CITY OF ALBUQUERQUE

**Planning Department
Transportation Development Services Section**

Re: Certification Submittal for Final Building Certificate of Occupancy for
Padilla Marble, [M-10 / D16E]
6901 Huseman Place SW
Architect's Stamp Dated 05/08/08

**Re: Padilla's Marble, 6901 Huseman Place NW, Traffic Circulation Layout
Architect's Stamp dated 8-14-06 (M10-D16E)**

GRADING PLAN

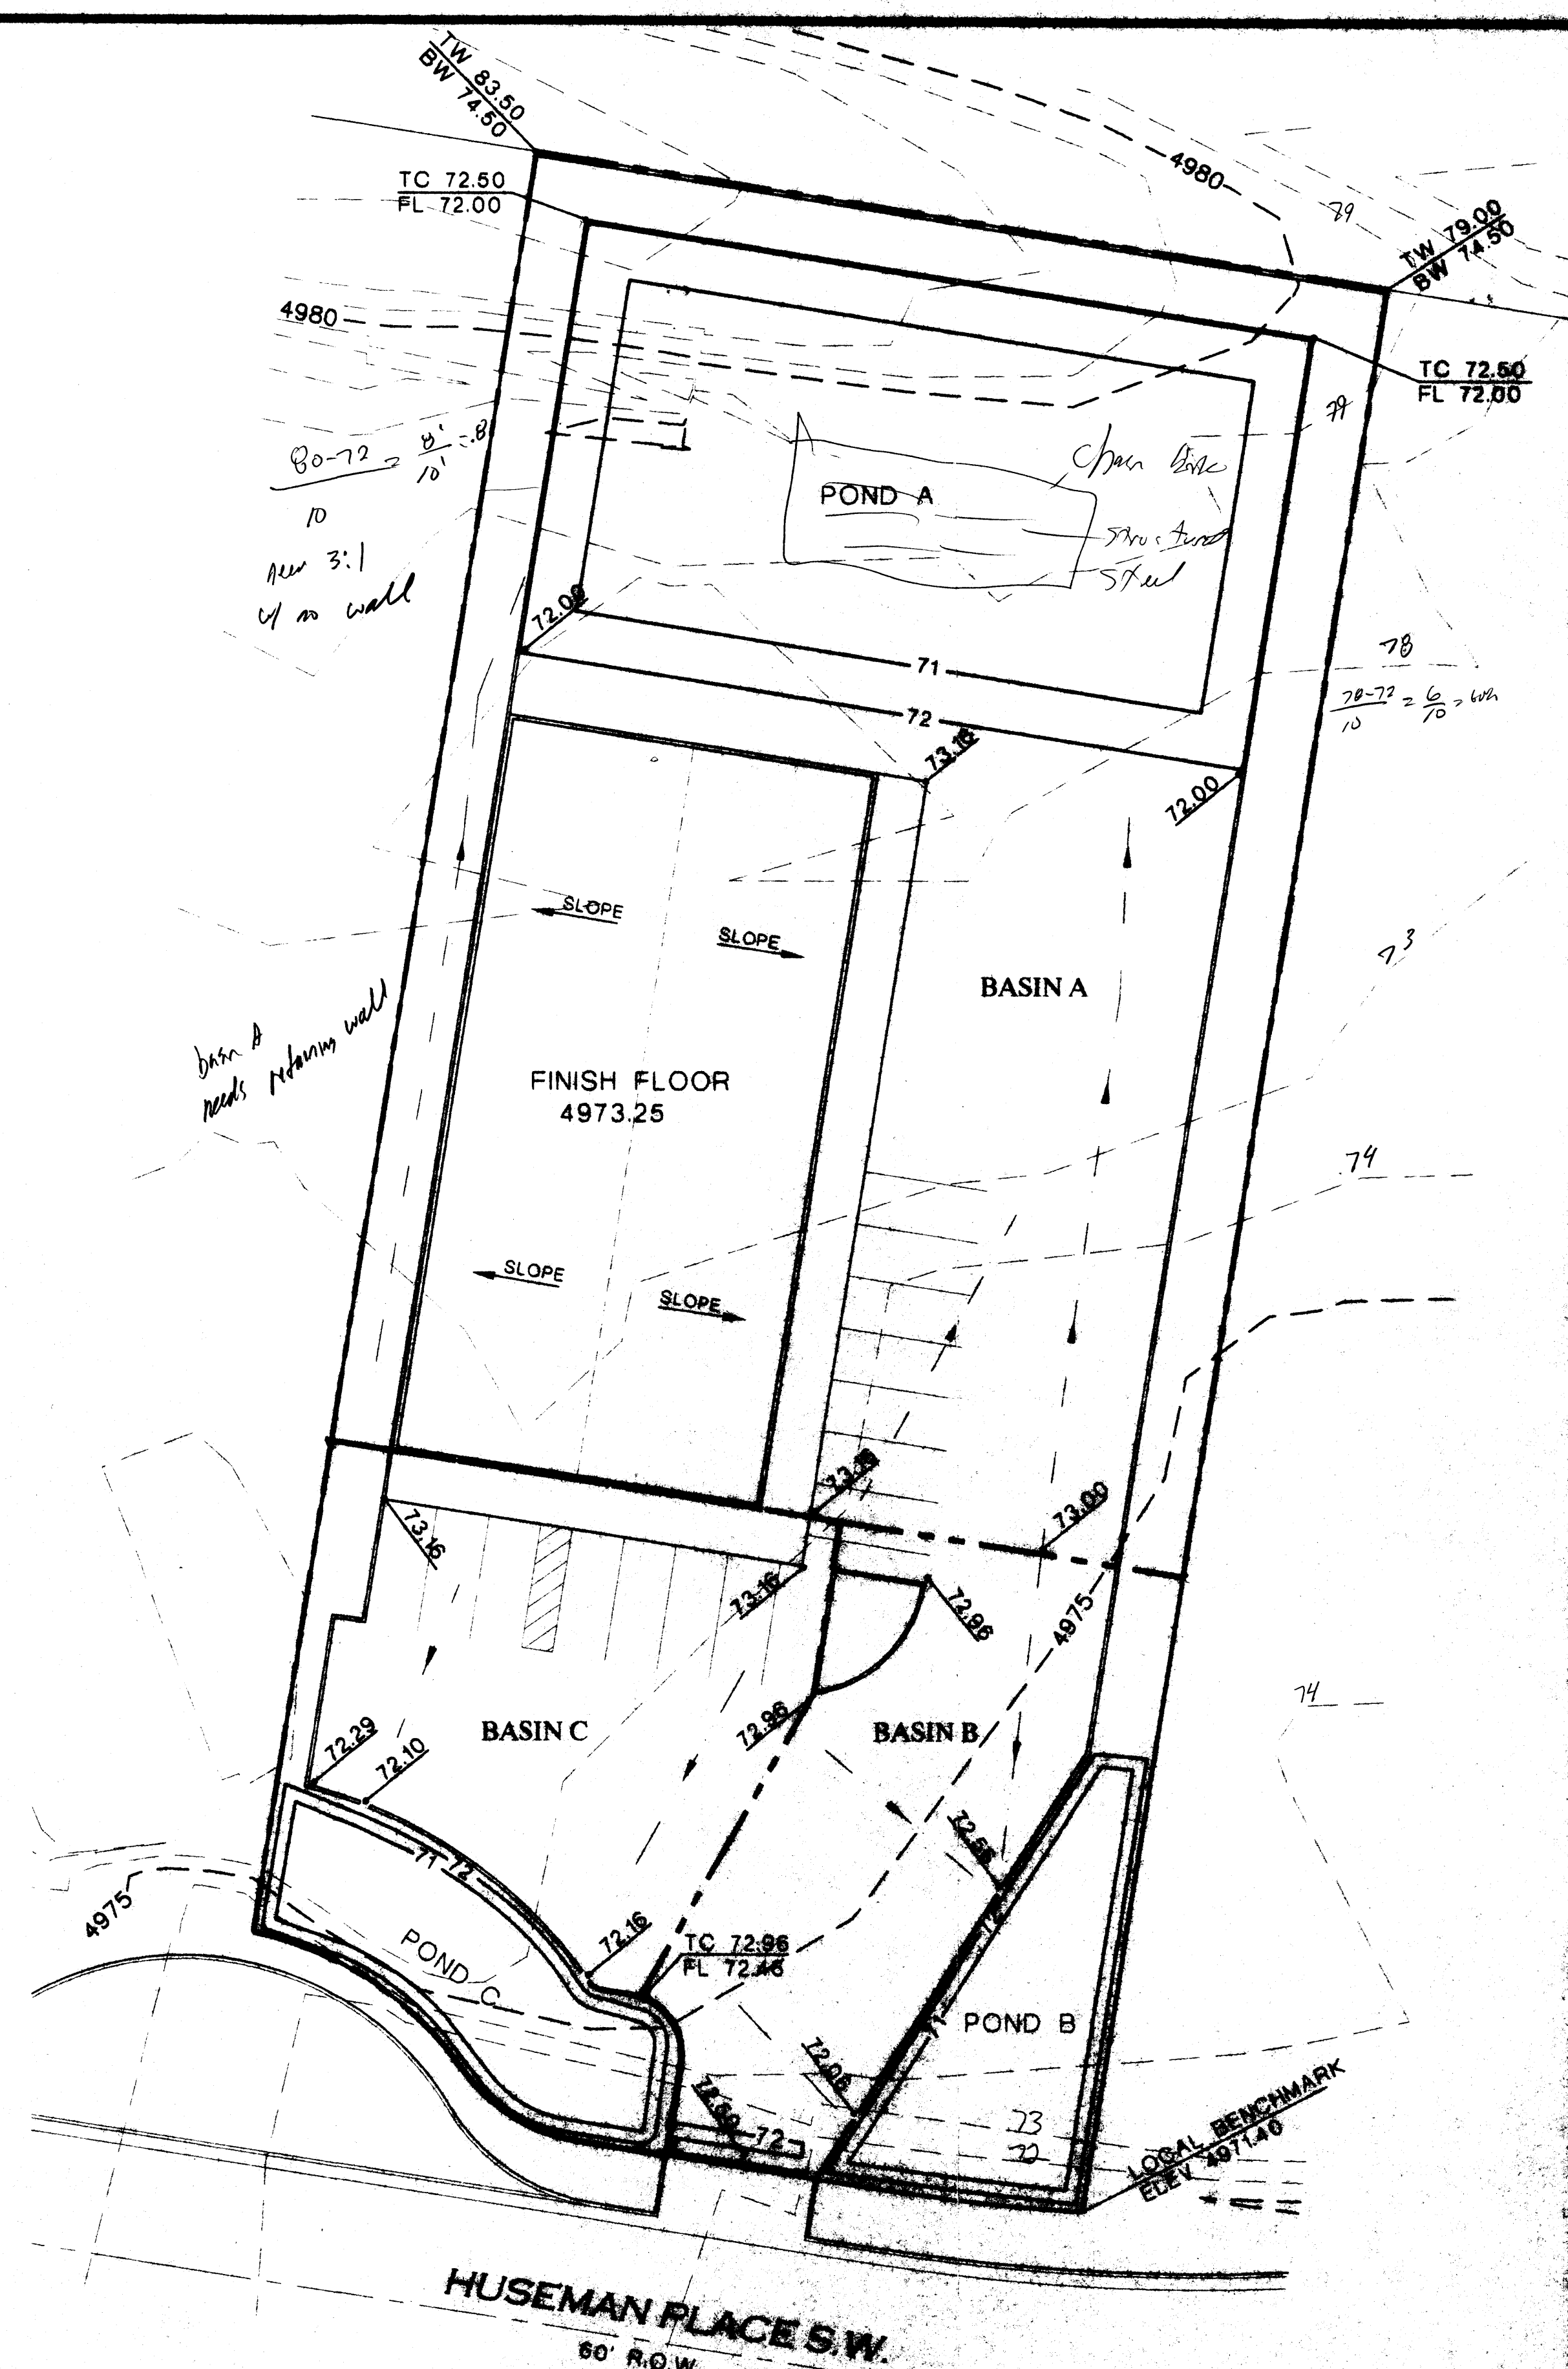
- The 100 year-10 day storm volume should be used for calculation retention pond volumes.
- Acreage for Basins B and C seem to be incorrect.
- Land treatments for Basin A appear to be incorrect.
- Is there a high point at the south end of the building? Provide spot elevations.
- Provide direction of roof flows.
- Please correct the 71 contour typo for Pond C.
- Is the pond bottom in Basin C impervious?
- Are there retaining walls on the east and west perimeters? Provide spot elevations.
- Do any offsite flows enter the site?

- The 100year 10 day Storm has been used with this re-submittal
- The drainage basin areas for Basin B and C have been corrected
- The land treatment for Basin A has been updated
- There is a high point at the south end of the building that creates drainage basin A and B. A spot elevation has been shown
- Roof flows are indicated on the plan
- The 71 contour has been corrected
- The bottom of pond c is not impervious.
- There are no retaining walls on the east and west, the subdivision was "benched" at each lot with the original grading scheme
- There are not any offsite flows entering this property
